Date 09 December 2019

**RE: 6/2019/1788/COND – Former Shredded Wheat Site, Broadwater Road, Welwyn Garden City, AL8 6UN**

Thank you for re-consulting us on the above application for the submission of details pursuant to condition 5 (Surface water Discharge) 6 (Drainage System) 52 (Provision of open space/play space) 35 (Delivery of accessible Housing) 13 (Highways) 37 (Vehicle access Point to Pall Mall Site) 50 (Refuse Storage Arrangements) on planning permission 6/2018/0171/MAJ, at Former Shredded Wheat Site, Broadwater Road, Welwyn Garden City, AL8 6UN.

Dig Title: **ATTENUATION POND DETAILS
PHASE 1
SHEET 1**

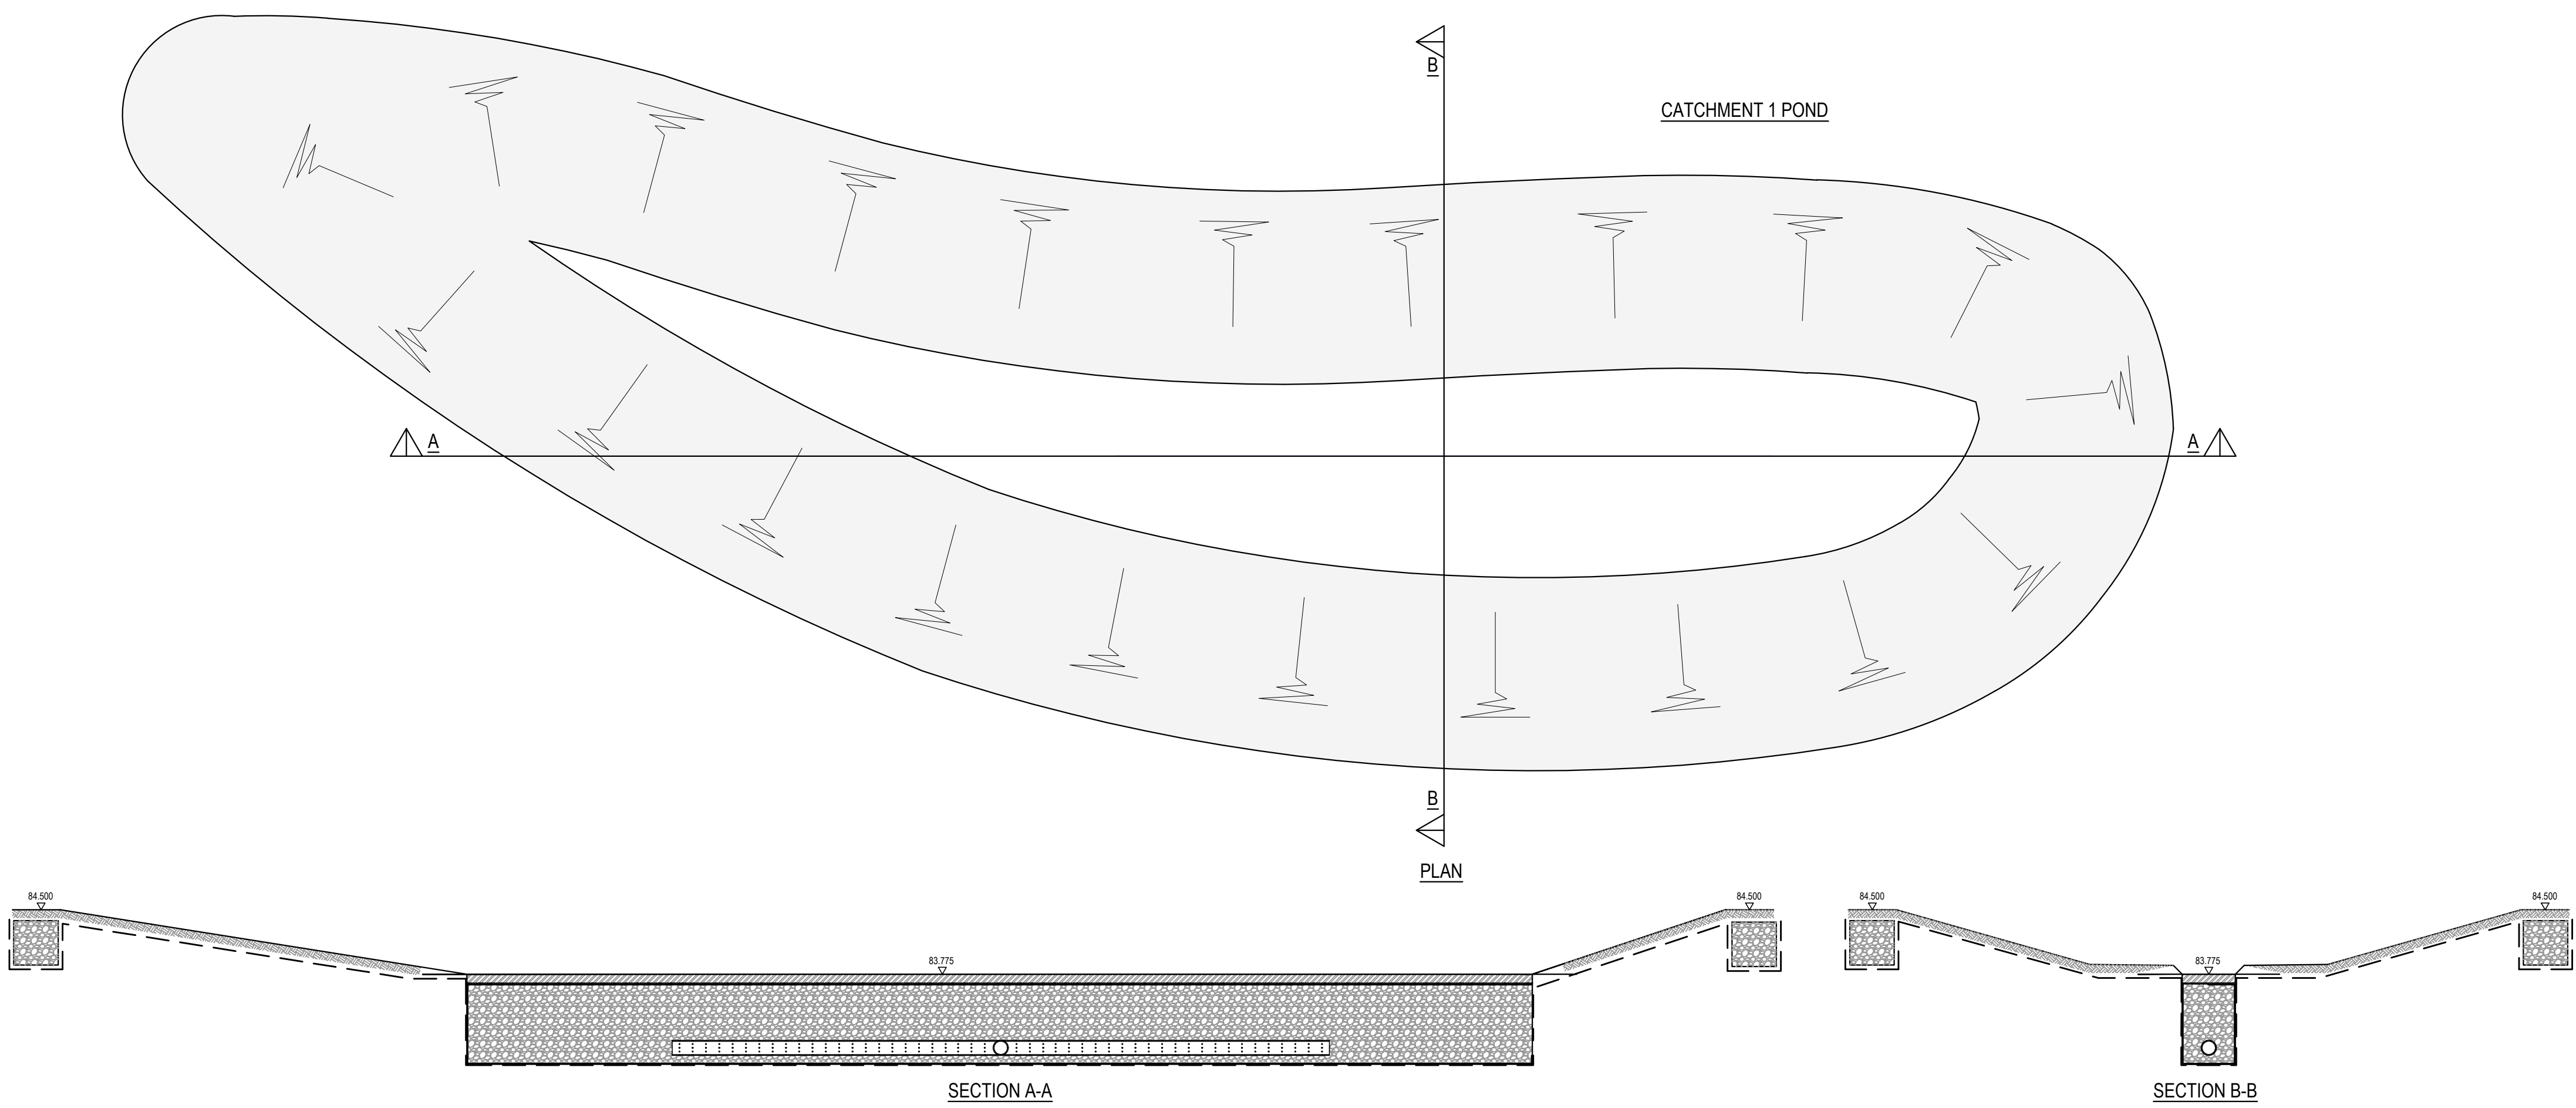
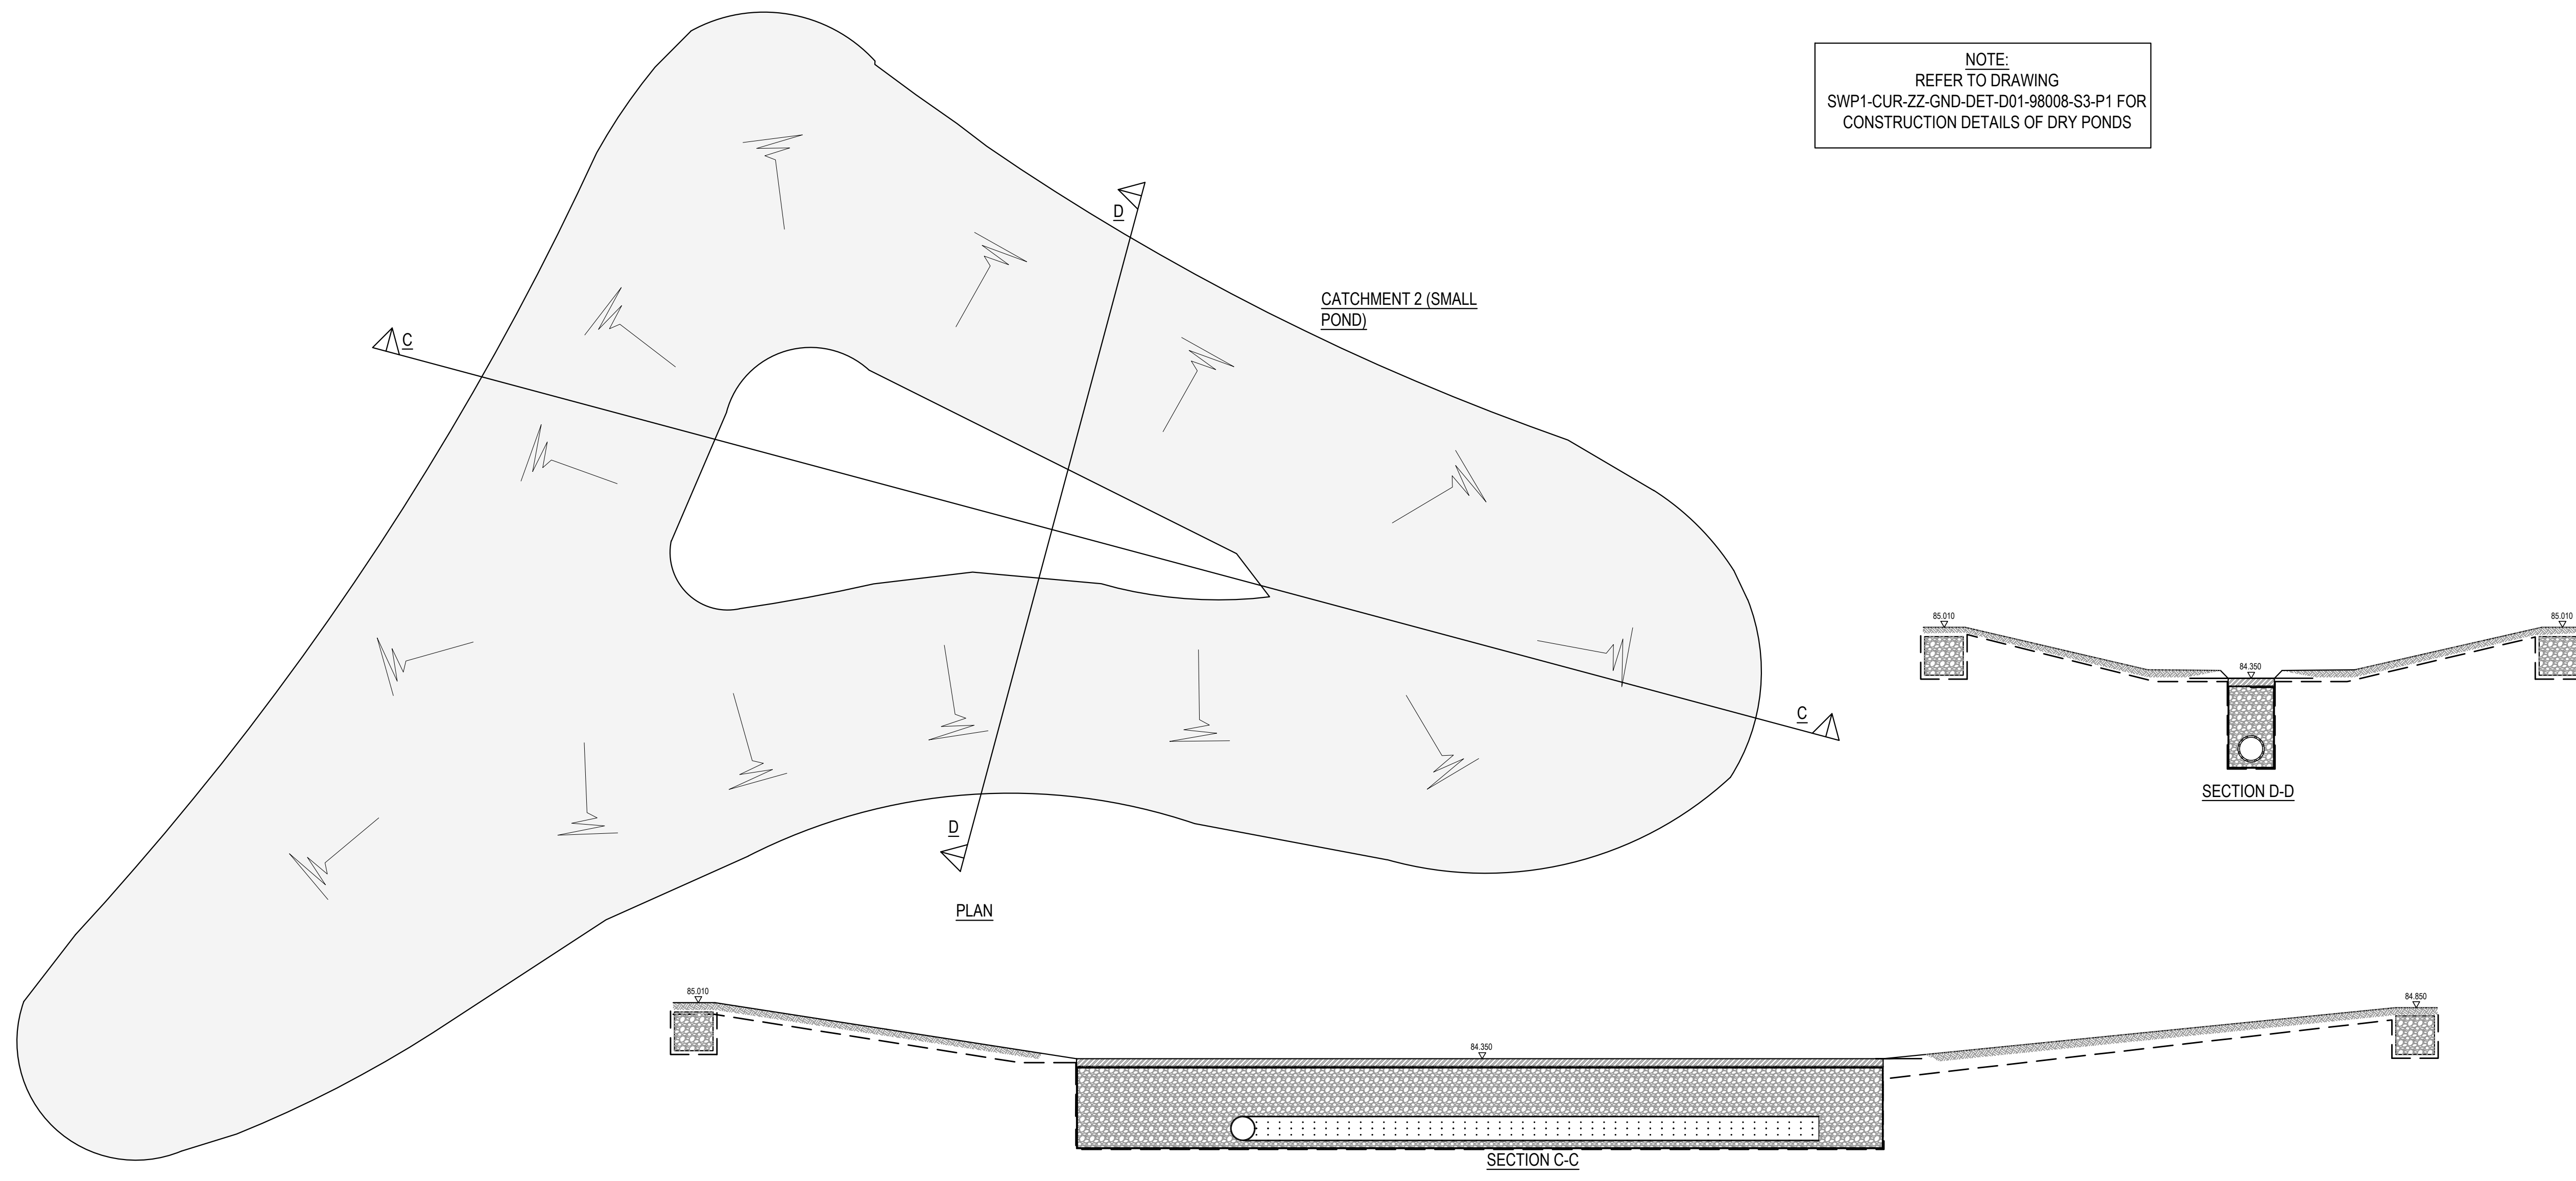
We would advise that full details of two overflow basins/ dry swales located to the south west from the development site should be provided, as they will provide significant storage volumes for the development site.

Based on the assessment of the submitted information, no detailed engineering drawings of the proposed tanks and dry swales have been provided.

Details for the swales can be seen on drawing 066571-CUR-00-XX-DR-C-98008. Further information is required from the LLFA if this has been deemed not sufficient.
